An Bord Pleanála,
64 Marlborough Street,
Dublin 1,
D01V902

Re: "DART+ West Electrified Railway Order 2022"

Please find attached my observation in respect of the above railway order pertaining the partial acquisition under CPO of Ashtown Stables for the purposes of a proposed access road at Ashtown due to the proposed level crossing closure at Ashtown.

MAY MDC LAN ROUT DR U 15100 D

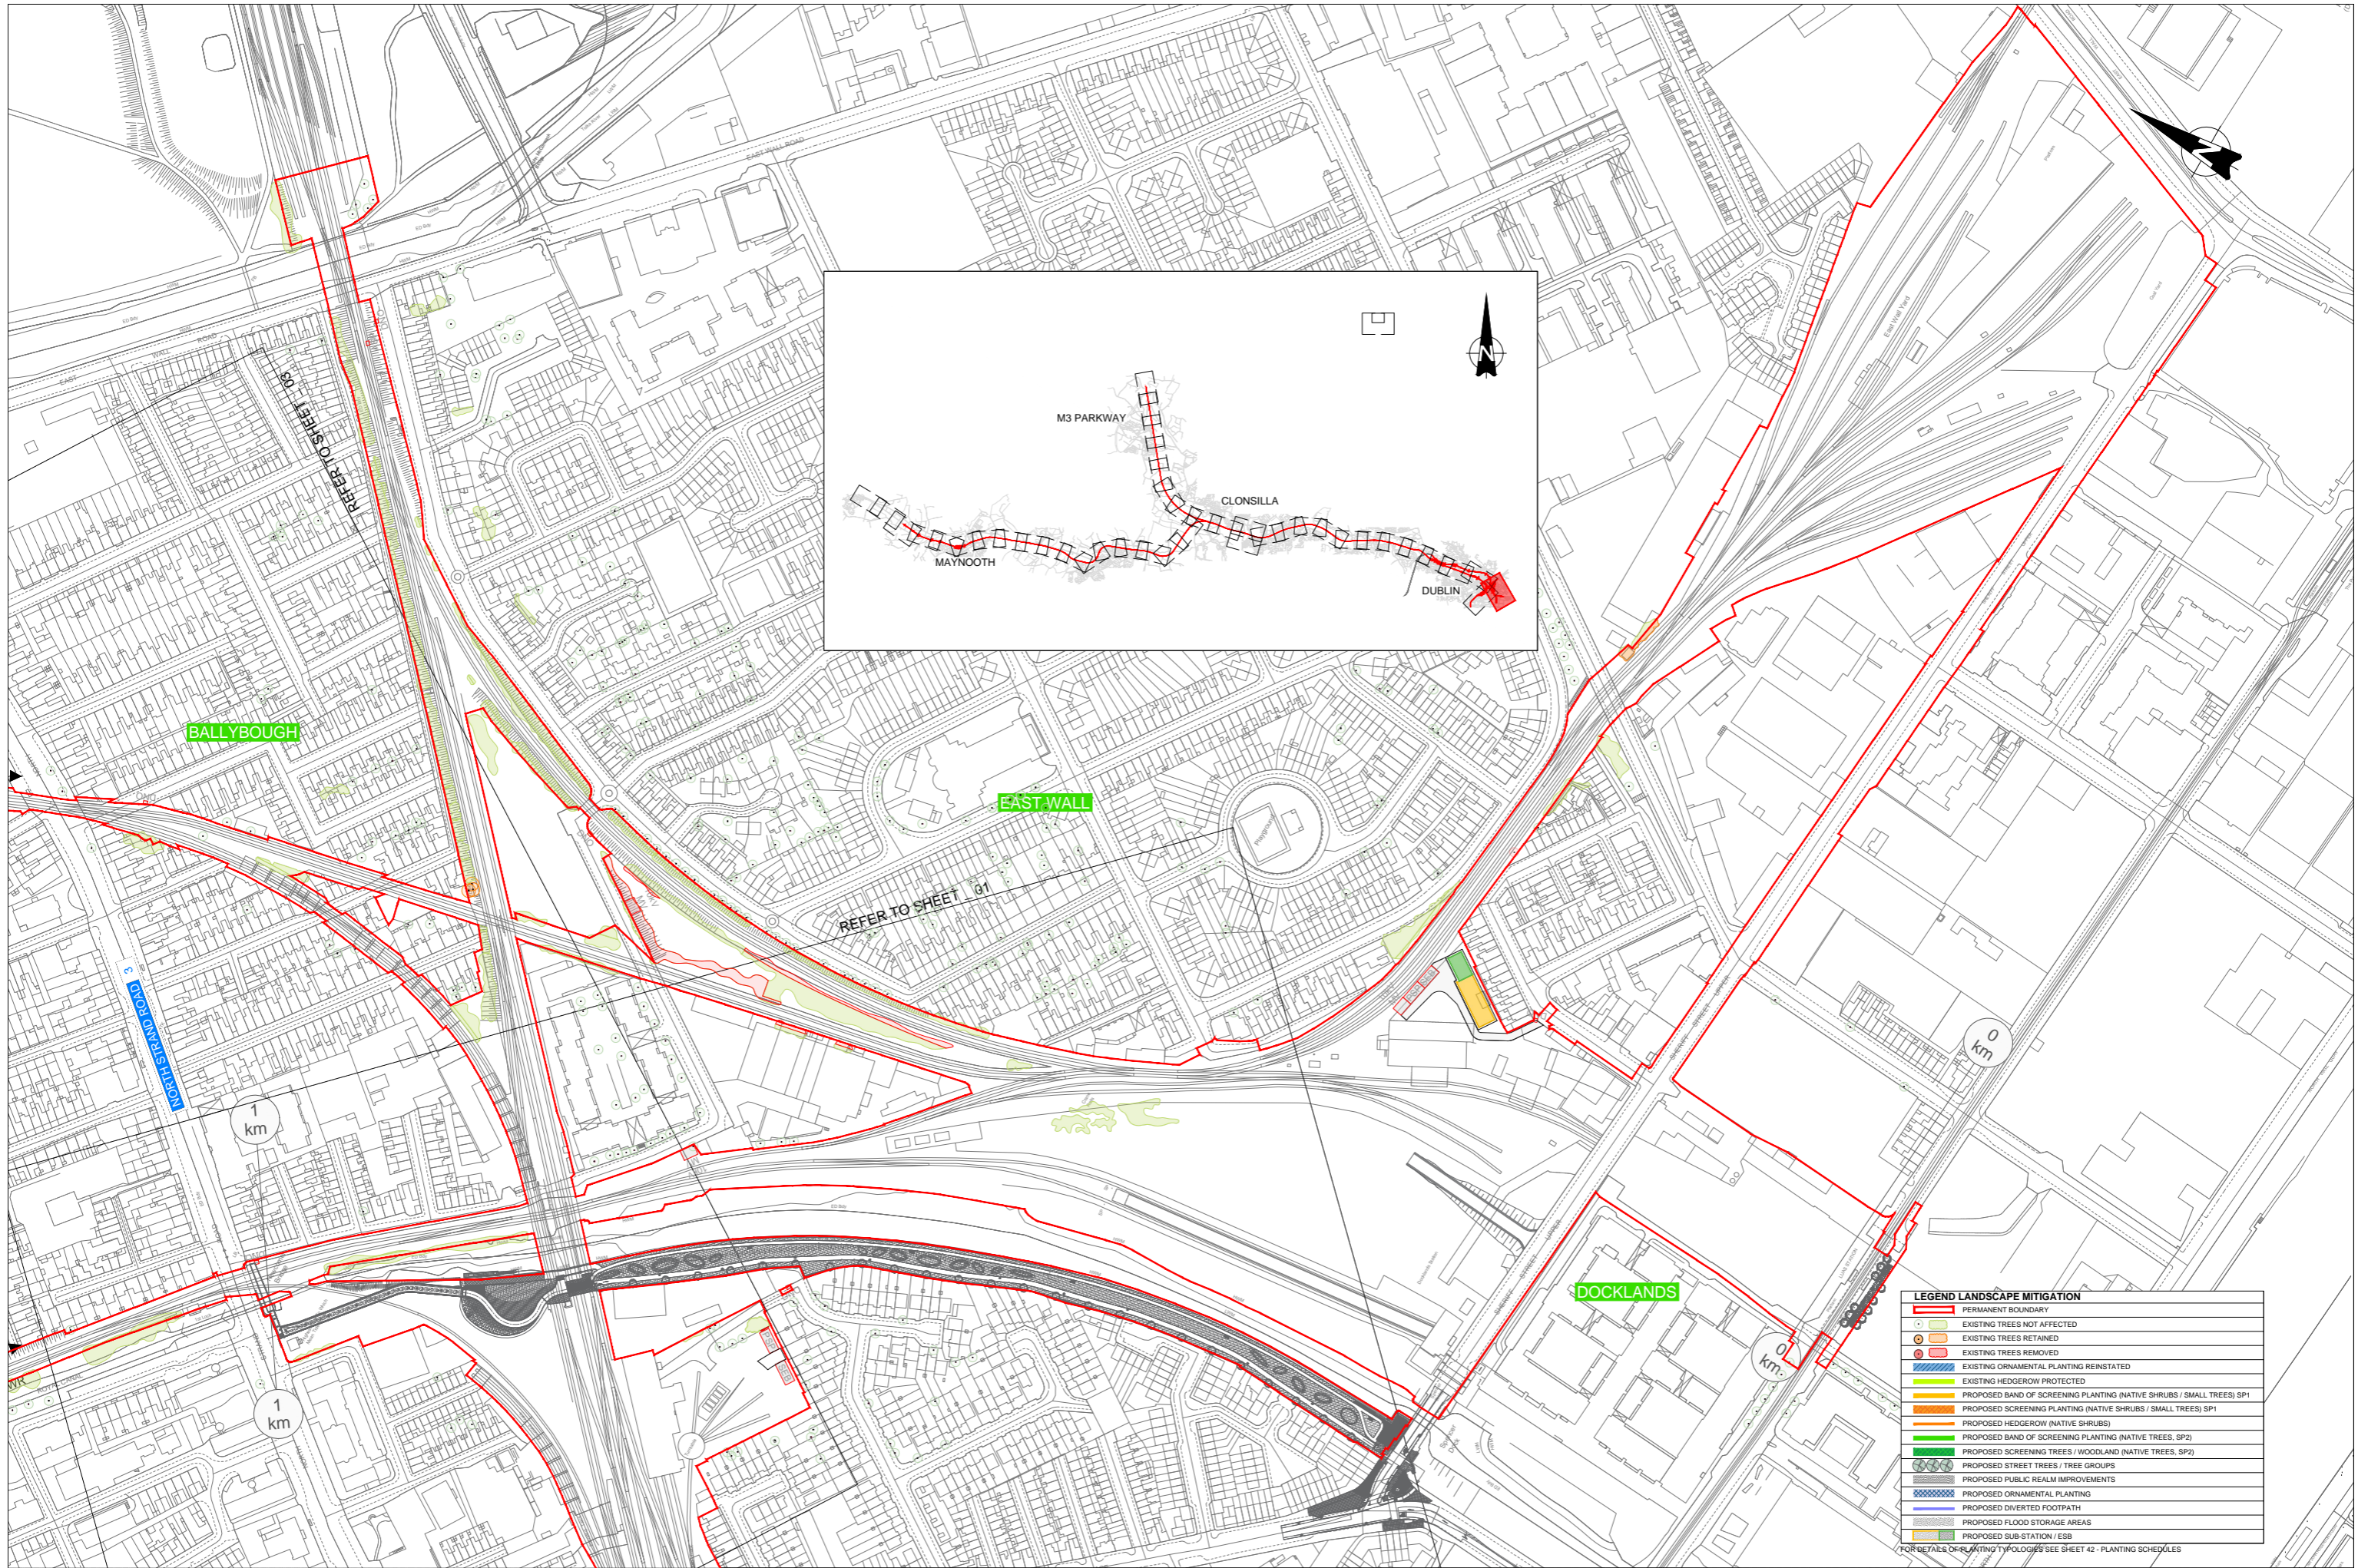
Here trees and hedgerows for removal are not documented in the landscape impact drawing yet is on the proposed mitigation plan. A new boundary condition is required to the south and south west. Yet the specific trees and hedging are not specified. For

example *Quercus robur* (English Oak) and *Quercus palustris* (pin oak) are described as the type of trees that may be used as street trees on drawing 15108 . Both oaks are toxic to equines and demonstrates that no consideration was given to the planting scheme 15108 which pertains to Ashtown Stables. *Quercus palustris* is a non-native tree is inappropriate as a reinstatement of the native trees and hedgerow that are extant on the lands of Ashtown Stables. To the south west the existing vegetation, trees and hedgerow are noted as retained yet a new boundary condition is proposed on section C-C aforementioned. Any trees specified are at a maximum girth size of 10-12cm girth or maximum height of 2.5m tall or as whips at 900mm tall. 'Street' trees are a maximum size of 16/20cm girth (no height specified). 10-12cm girth is not a 'semi-mature' tree and whips at 900mm tall will be significantly poorer in visual amenity for the foreseeable future to that which the public currently enjoy. The meagre planting schedule presented cannot replace the current setting in any meaningful way.
